Our Case Number: ABP-314610-22

Re: BusConnects Ballymun/Finglas to City Centre Core Bus Corridor Scheme
Ballymun/Finglas to Dublin City Centre

**Re: Observation on a Strategic Infrastructure Development Application:
Ballymun-Finglas Route to City Centre**

Programme Title: BUSCONNECTS DUBLIN CORE BUS CORRIDORS INFRASTRUCTURE WORKS			
Drawing Title: BALLYMUN / FINGLAS TO CITY CENTRE CORE BUS CORRIDOR SCHEME TRAFFIC SIGNS & ROAD MARKINGS			
Drawing File Name: BCIDD-ROT-TSM_GA-0304_XX_00-DR-CR-0022	Sheet Number: 22 of 37	Status: A	Rev: M01

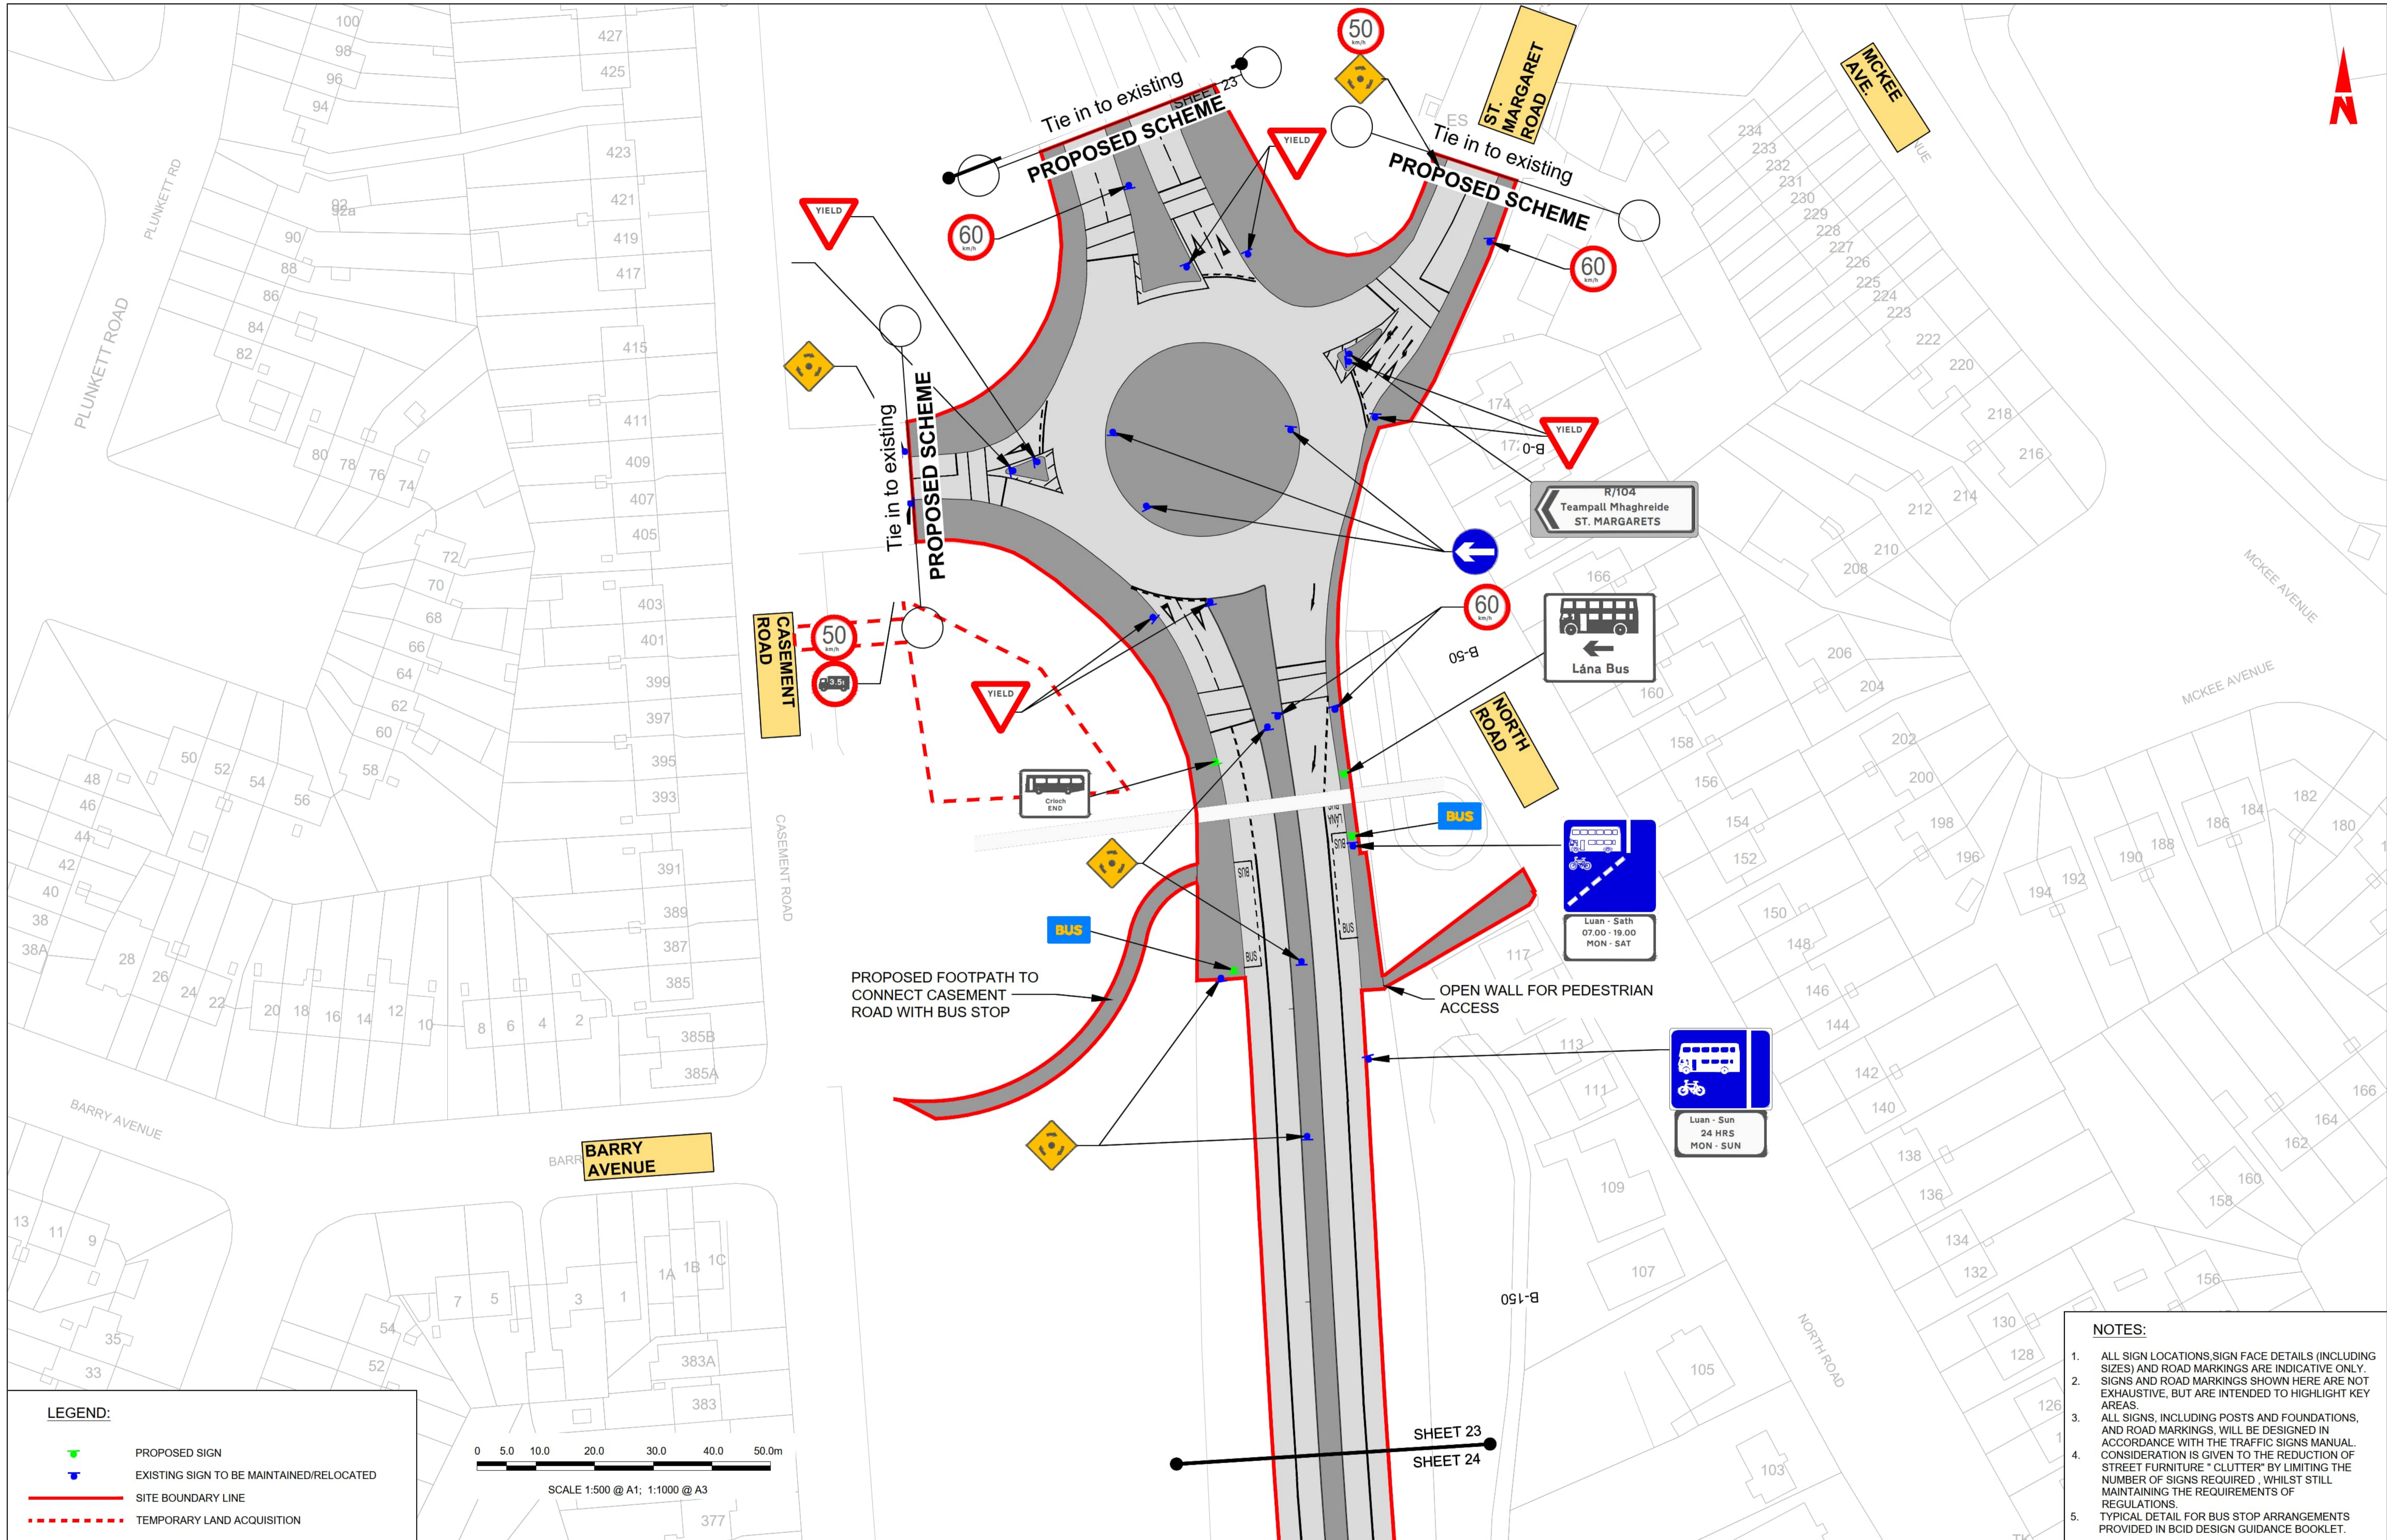
Sheet no 22 of 37

-The addition of a pedestrian crossing outside Botanic Gardens to provide for pedestrian and universal access is greatly needed and would act as traffic calming mechanism, even in the current conditions.

-Do not decrease public (pedestrian realm) at corner of Botanic Avenue and Botanic Road. This is already a congested area along the footpath and more public space is required. There is insufficient space for the moved bus shelter location and will only add to street clutter.
